Consultee Comments for Planning Application 21/00854/FUL

Application Number: 21/00854/FUL

Address: Abbey Bottom Farm Harwich Road Wix Manningtree Essex CO11 2RY

On Behalf Of: Tree & Landscape Officer

drawing title:
Block and Site Plan

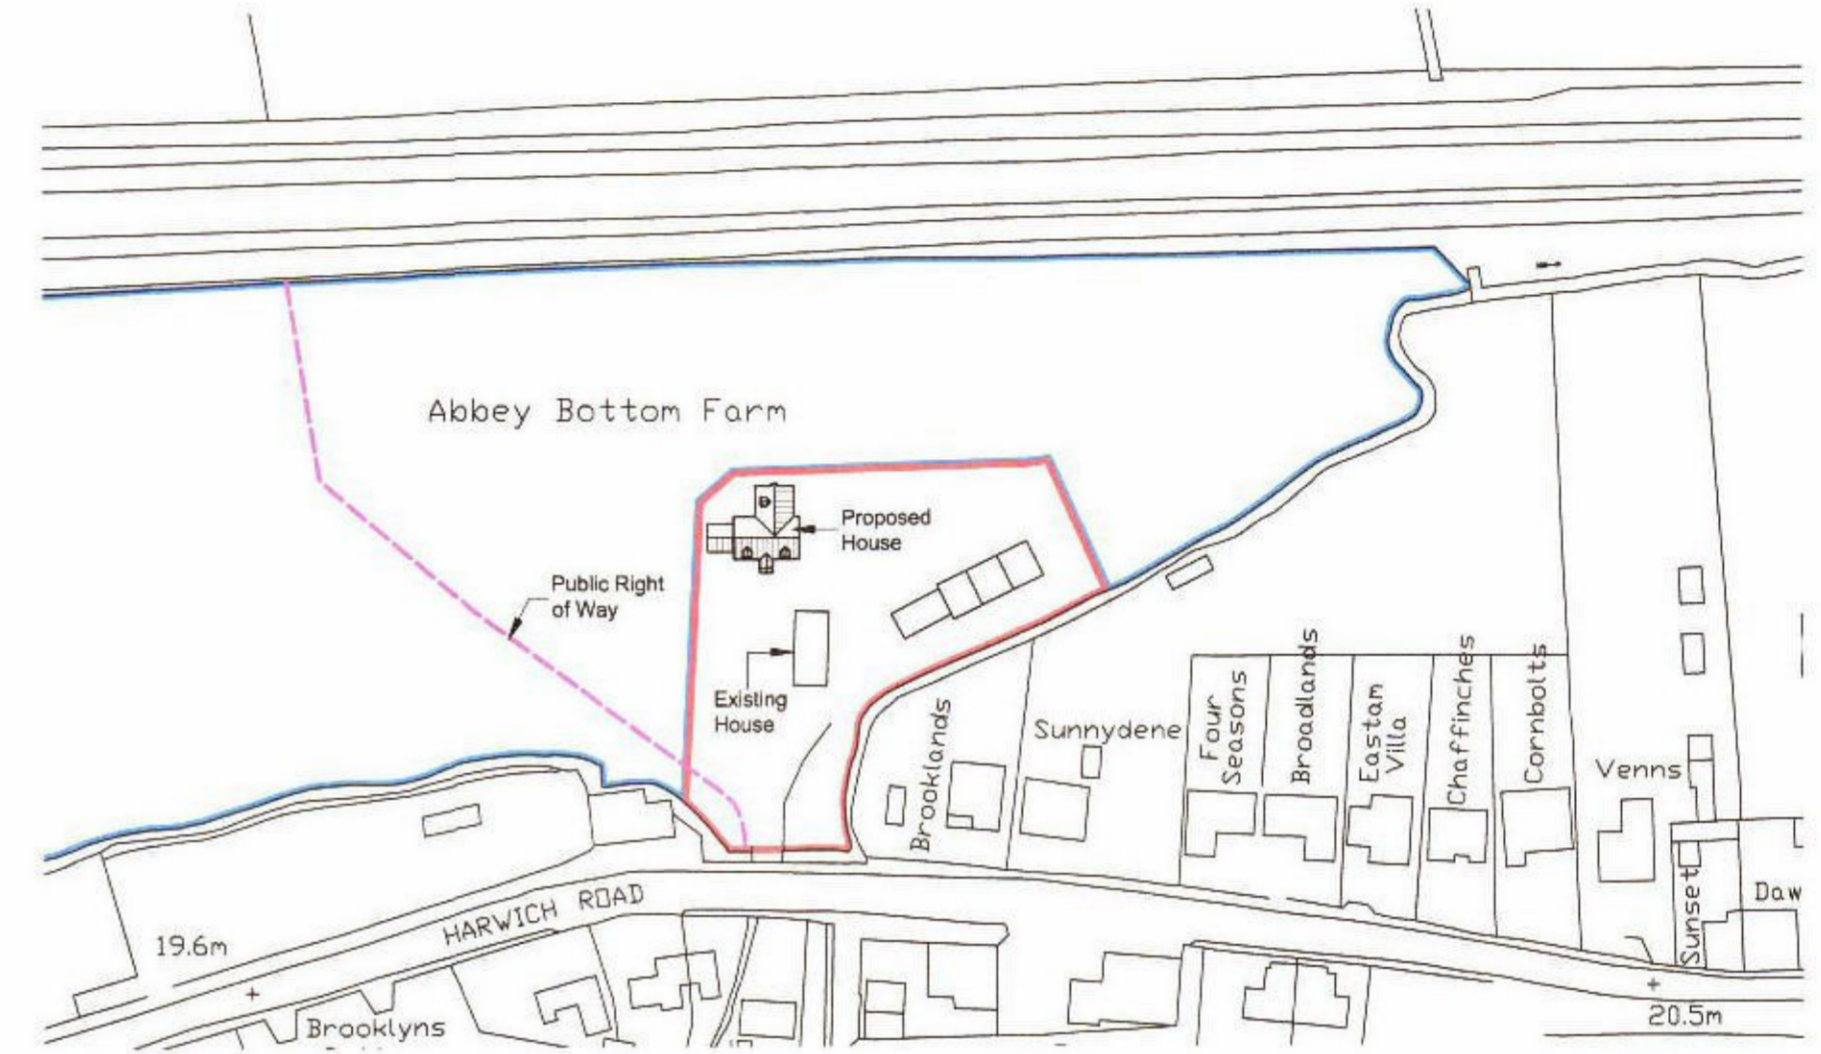
The application site does not contain any significant trees or other vegetation. The site plan shows the retention of the small Goat Willow situated to the front of the existing dwelling.

In this regard it would be desirable to secure new planting on the western boundary of the application site to achieve a degree of softening and screening of the dwelling when viewed from the PRoW. A low hedge comprising indigenous species such as Hawthorn, Field Maple, Dogwood and Guelder Rose would be appropriate with small trees such as Rowan or Whitebeam at 5m centres.

Site boundaries should be demarcated by low post and rail fences as 2m tall close board or panel fences would be unsightly and incongruous in this setting.
